Please ask for: Nicola Moore
Email: nicola.moore@arun.gov.uk
Telephone: Ext 37944
Our Ref: AB/19/22/HH
Your Ref:
Date: 3rd March 2022

Application for Planning Permission for Works or Extension to a Dwelling

Development: Proposed side extension, loft conversion, changes to external finishes, together with internal alterations and all associated drainage works
Location: 39 Priory Road Arundel BN18 9ET

LOFT PLAN / ROOF PLAN
AS PROPOSED
1:50

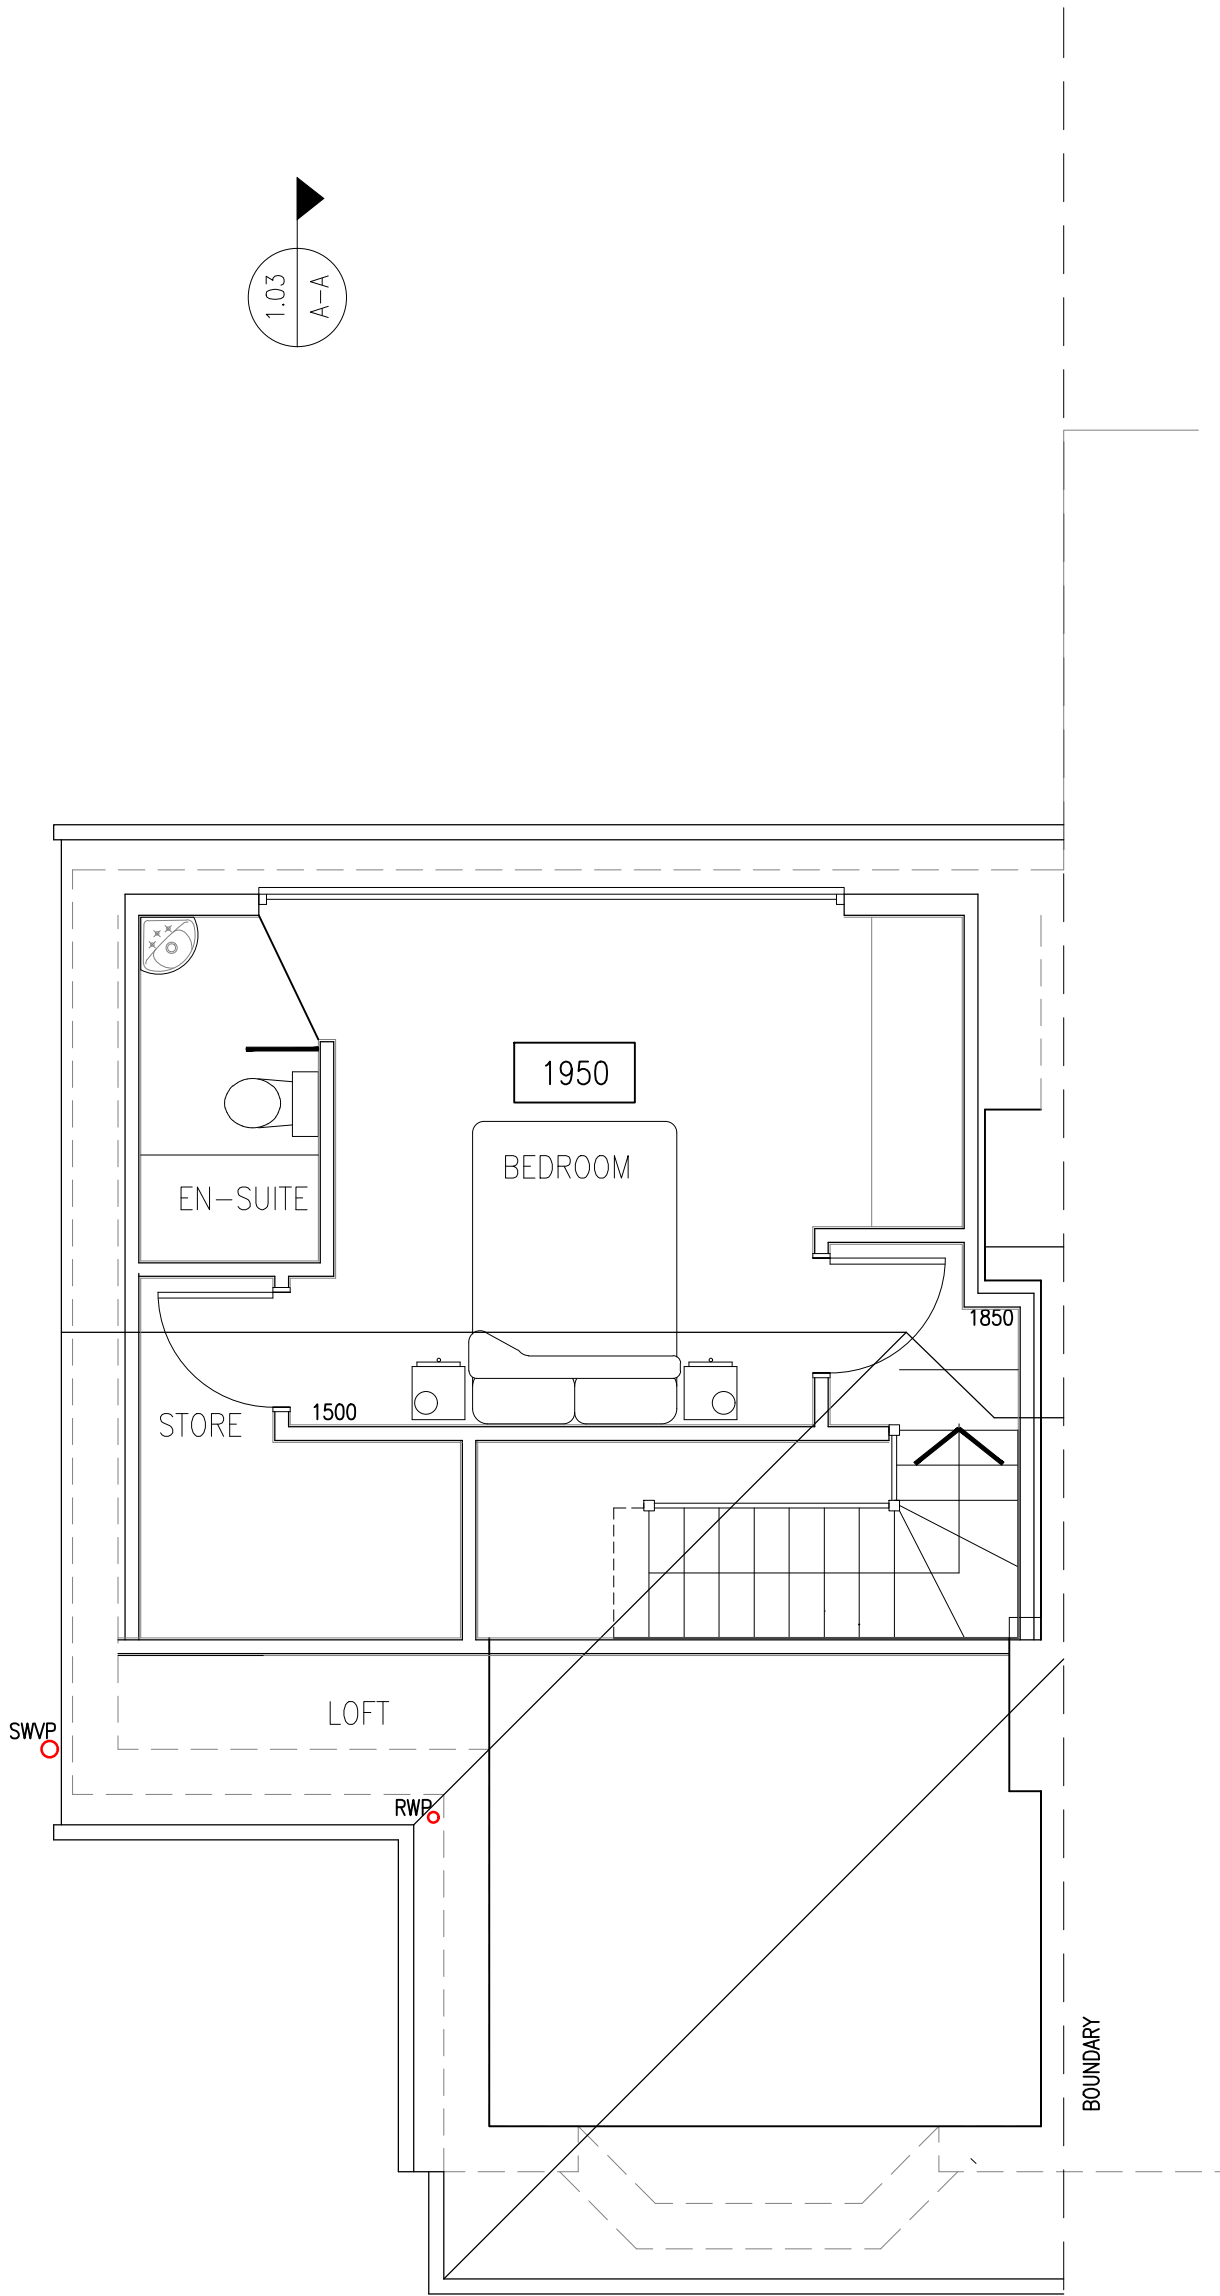
Roof Plan

Please submit electronic plans showing the existing and proposed roof plan. Please refer to the Validation Requirements List for further details.
